Current Zoning: N1-A (neighborhood 1-A), RE-3(CD) (research, conditional), OFC (office), CG (general commercial), B-1(CD) (neighborhood business, conditional)  
Proposed Zoning: UR-2(CD) (urban residential, conditional)

Approximately 33.03 acres located along the west side of John Adams Road, south side of Galloway Road, north of West Mallard Creek Church Road, and east of Interstate 85.

The petition proposes to develop a residential community containing a maximum of 345 single-family attached dwelling units in a townhouse style.

Kairoi Residential

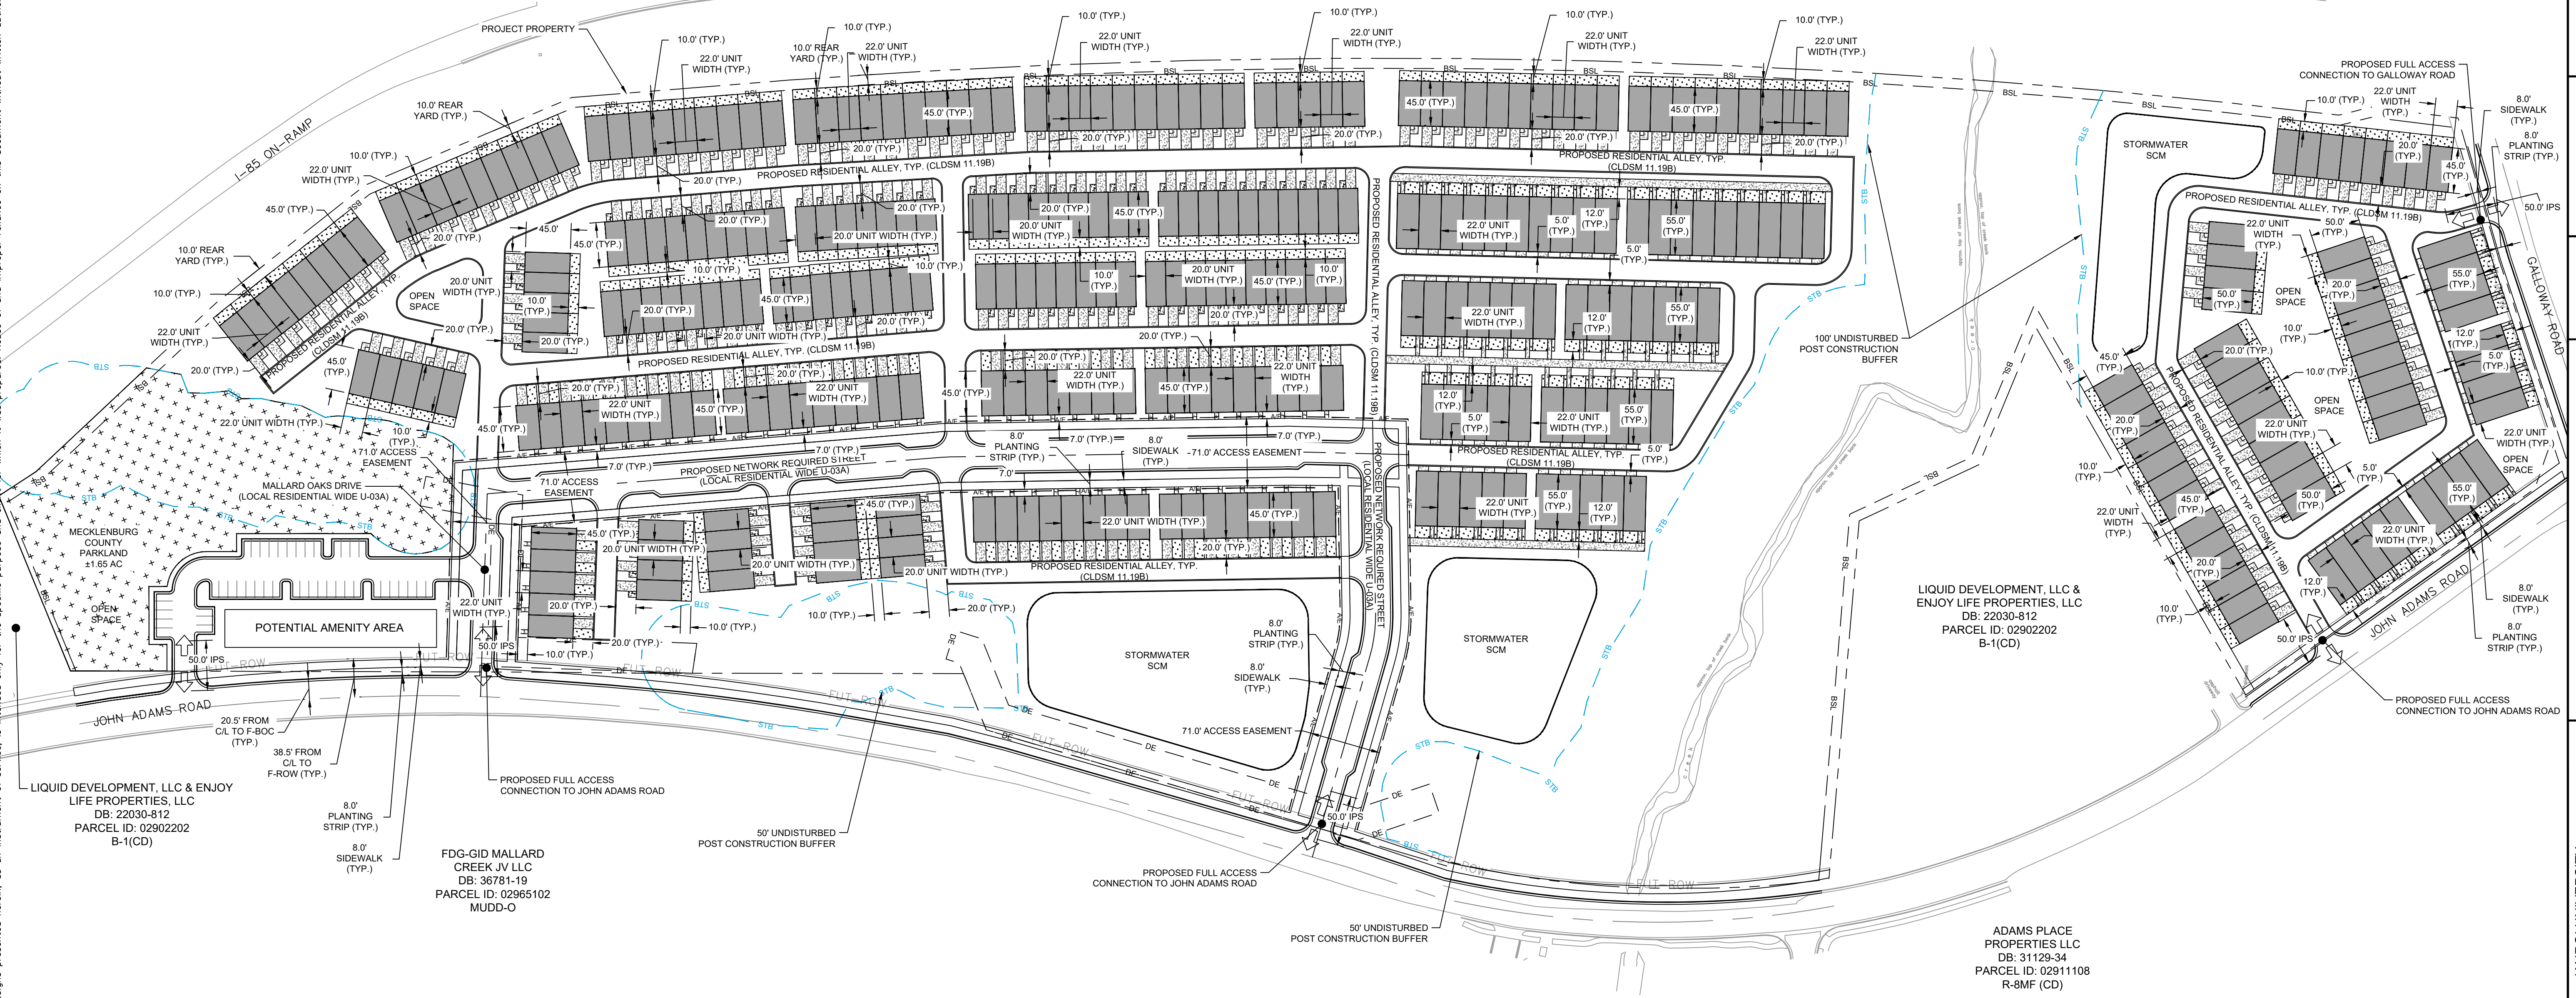
1. Consider relocating amenity area to a more central location within the site.
2. Show visitor parking for the Galloway Road section of the development.
3. Show dumpster and recycling location for the Galloway Road Section of the development.
4. Consider connecting the John Adams portion of the site to the Galloway Road portion via a walking trail.
5. Consider breaking up the 6-unit buildings into 4-unit buildings.
